**RE: 4720 ALEXANDER BLVD NE
RENAISSANCE CENTER**

The Architectural Review Board for the Renaissance Master Plan have reviewed and take no exception for the proposed remodel of the existing building located at 4720 Alexander Blvd NE, situated on Tract 11, known as Revel Entertainment.

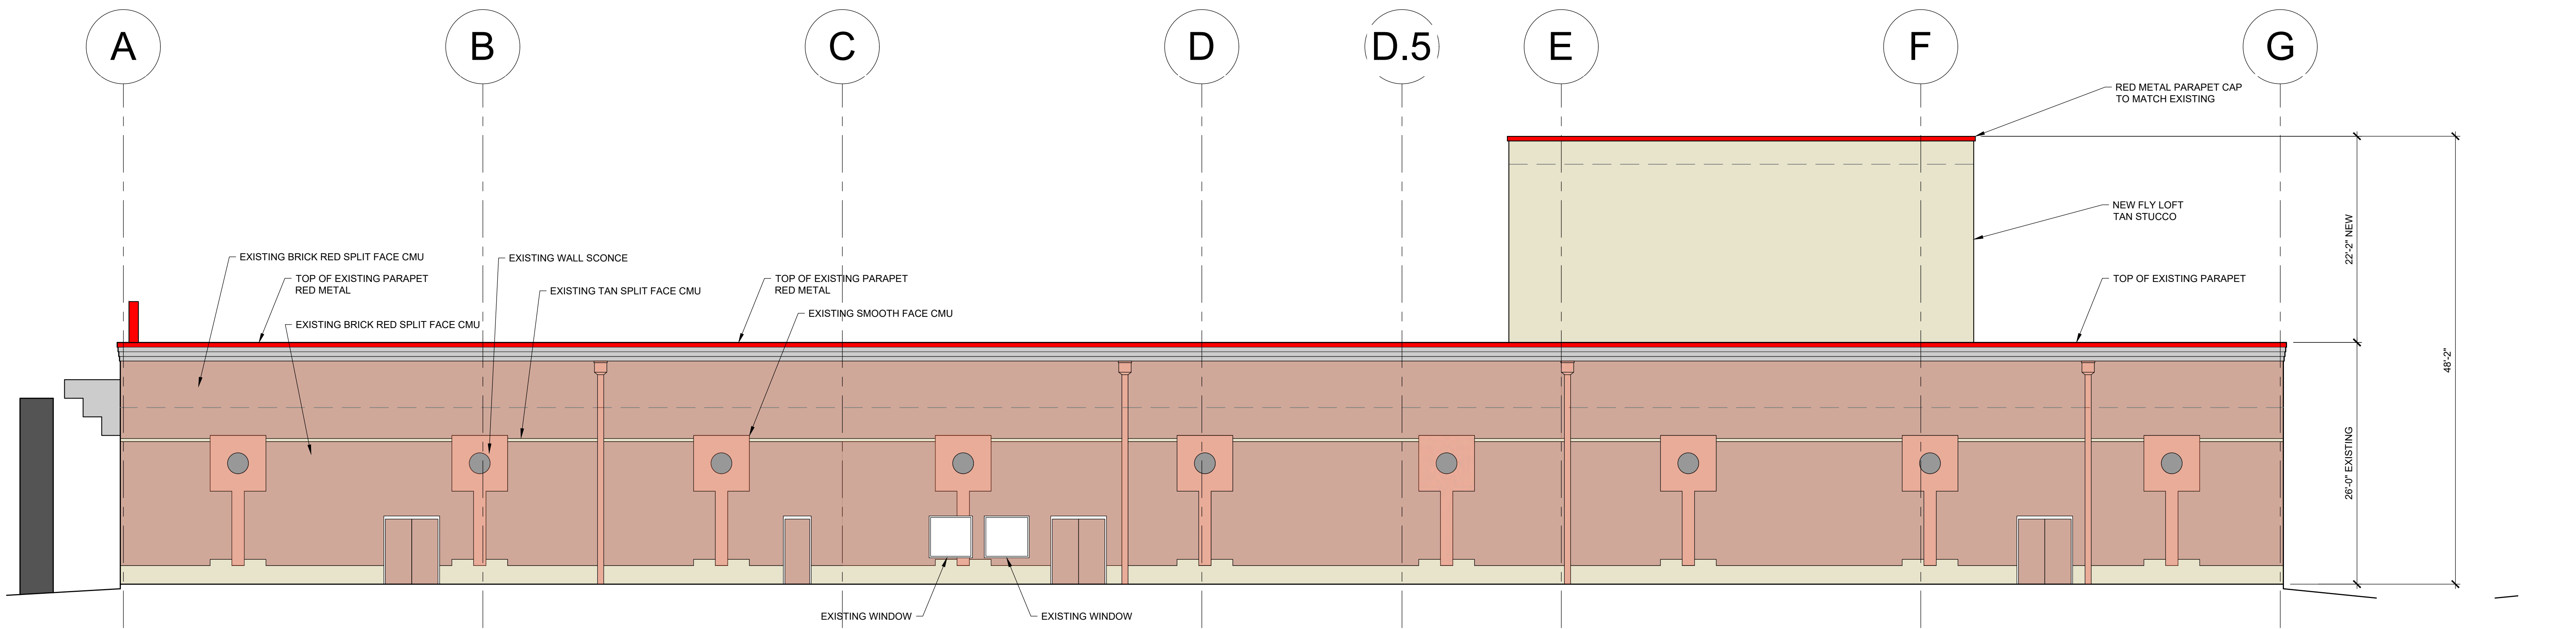
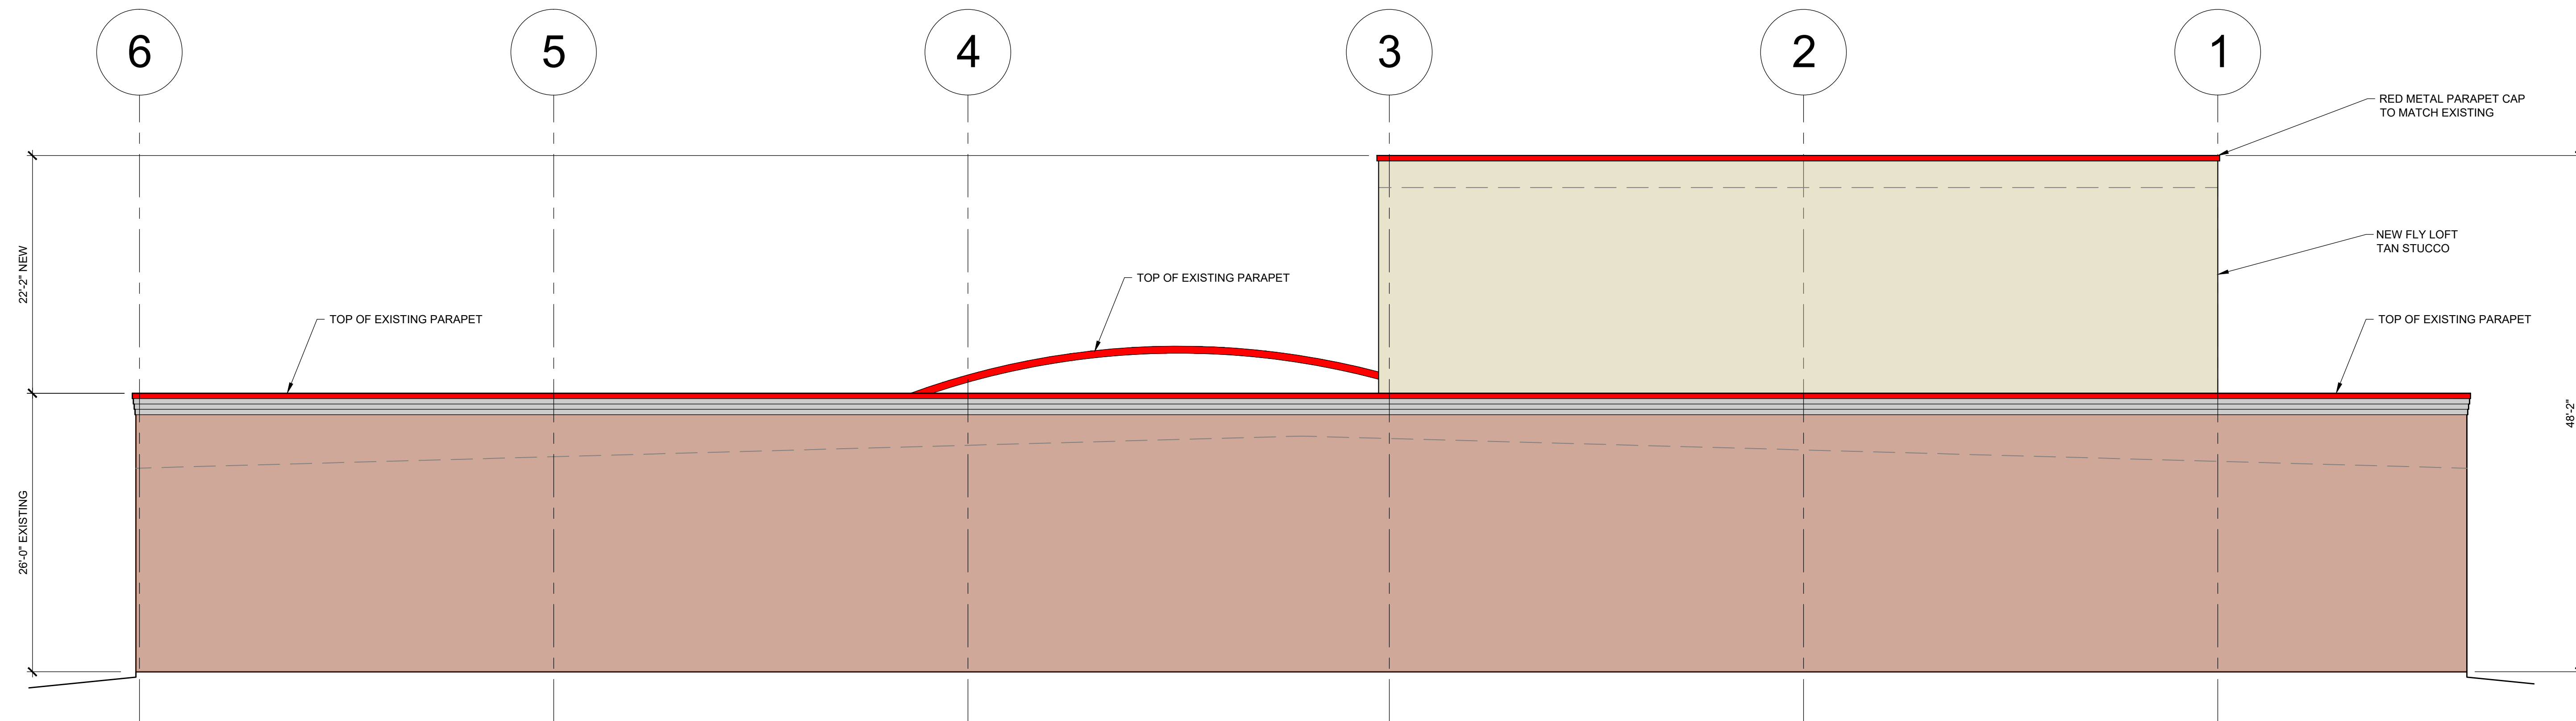
1. Remodel includes the building of a loft space, increasing a section of the existing building height by 15'.
2. Allowable height per Renaissance Center Master Plan is 2 stories, per Exhibit J Sector Table. This loft would be immediately above the 1st story use and thus be considered a second story.
3. Changes to the building will not result in exceeding allowable FAR as referenced in Exhibit J.
